SUFFOLK ENERGY ACTION SOLUTIONS'**REBUTTAL TO NGET RESPONSE TO SEAS RR
ALTERNATIVE SITES****SEA LINK: EN020026****SEAS IP:** [REDACTED]**DEADLINE: 2 – December 9, 2025****Date: 9 Dec 2025**

**[\[REP1A-043\]](#) - 9.34.1 Applicant's Comments on Relevant Representations
Identified by the ExA - Specifically Table 2.50 SEAS Alternative Sites**

- Legend
- Order Limits
 - Permanent Access Options
 - Saxmundham Converter Station Indicative Location
 - Bellmouths

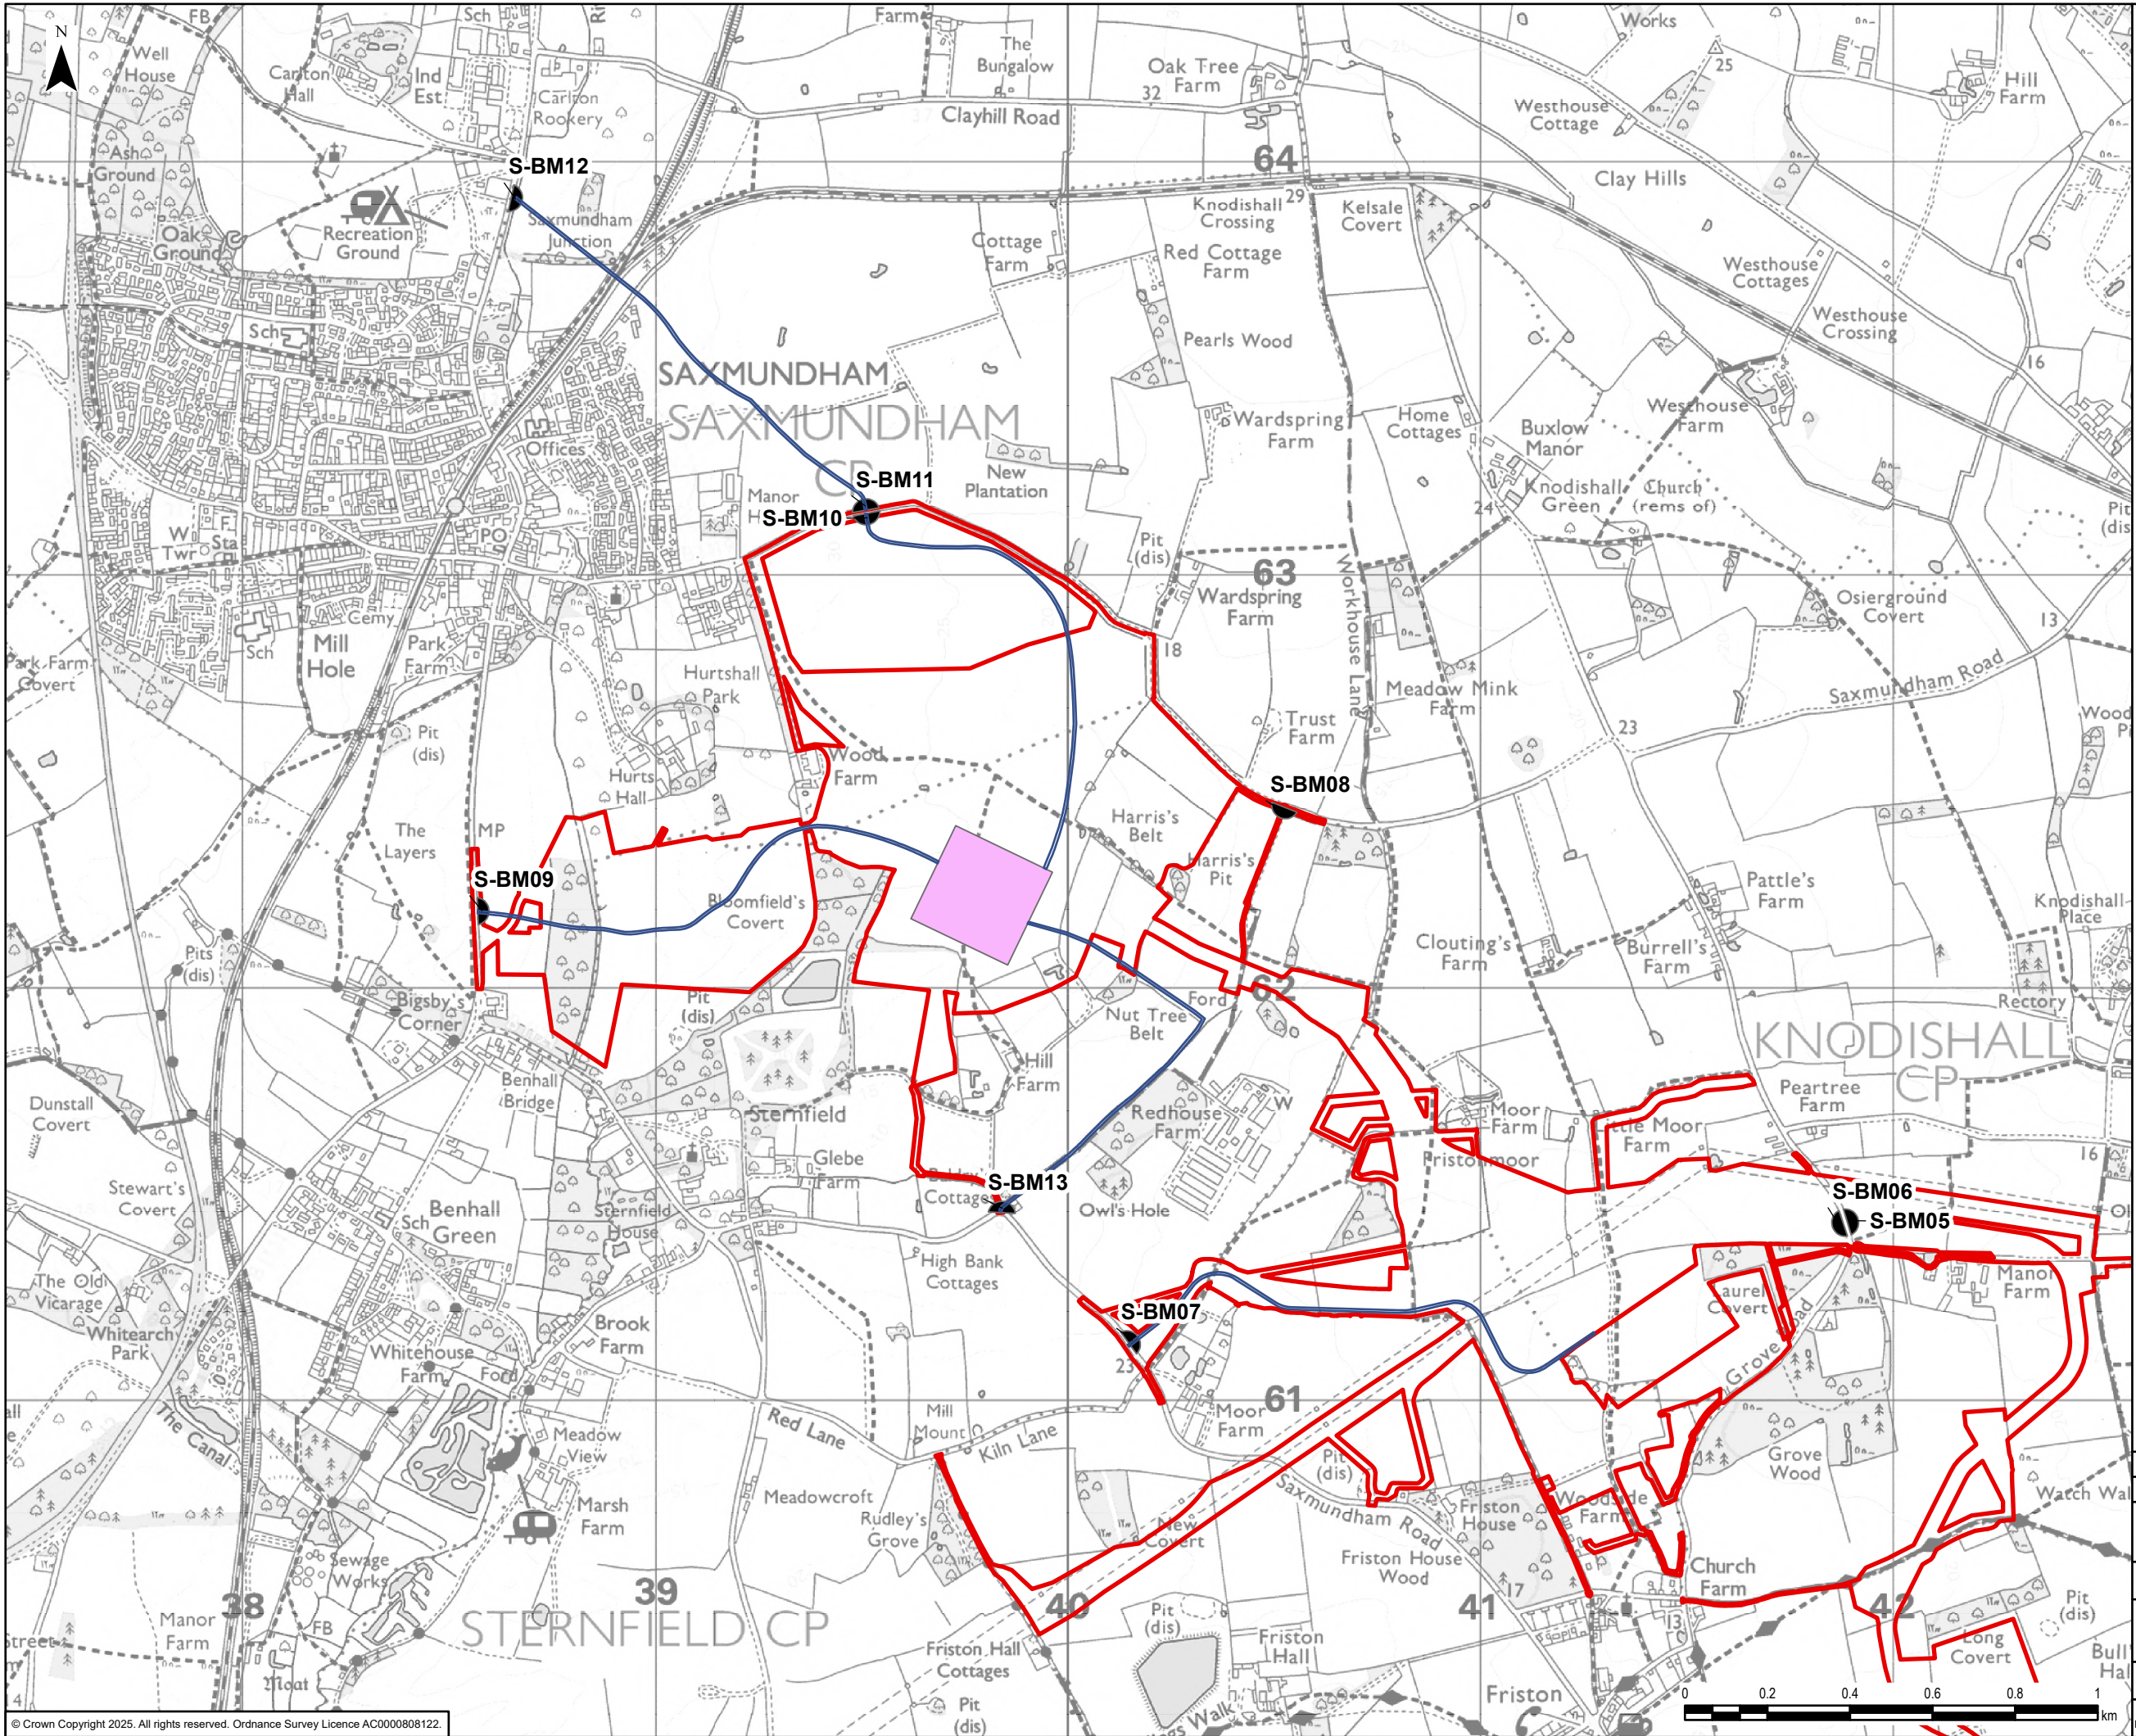
30 **B5.5-B5.7** These three paragraphs aim to show that the CPRSS (APP-368) correctly prioritised the five available options for Site 3 over the B1122/Sizewell Link Road access for site 4. NGET admit that access is constrained on both sites; but they then base their actual argument on just two points:

31 - *Access to Site 4 is ‘via a network of minor roads’.* It is presently, but this has not prevented SPR, SZC and a host of other developers from targeting networks of minor roads in Suffolk Coastal for NSIP projects. Friston, too, is accessed through ‘a network of minor roads’. NGET accept in this section that both Site 3 and site 4 will require an element of ‘off-highway’ access, but ignore the fact that the Site 3 access will *also* require one entirely new bridge for this access, as well as the rebuilding of another bridge at Benhall. Site 4 will require neither.

- 33 It is clear from both points that there are considerable access *advantages* for Site 4, and NGET's false claim of advantage for Site 3 cannot be substantiated – indeed, were the Fromus Bridge to be built, it would only become available after four to six months of construction traffic through Saxmundham streets, probably until Spring 2027. This is not '*avoiding disruption*', but is in fact a failure to meet the requirement to minimise adverse impacts on host communities set out in NPS EN-1 (4.15-4.17). The claim in B.5.7 that '*once the new access to the converter station and the Fromus Bridge is constructed, all construction traffic will use this access from the B1121*' is also fanciful, given that at this stage even the design and construction plans for the Benhall Bridge are not yet complete, as CR1-003, 4.5.4, for example, makes clear. No option has yet been selected, and therefore claims based on the final design must be premature.
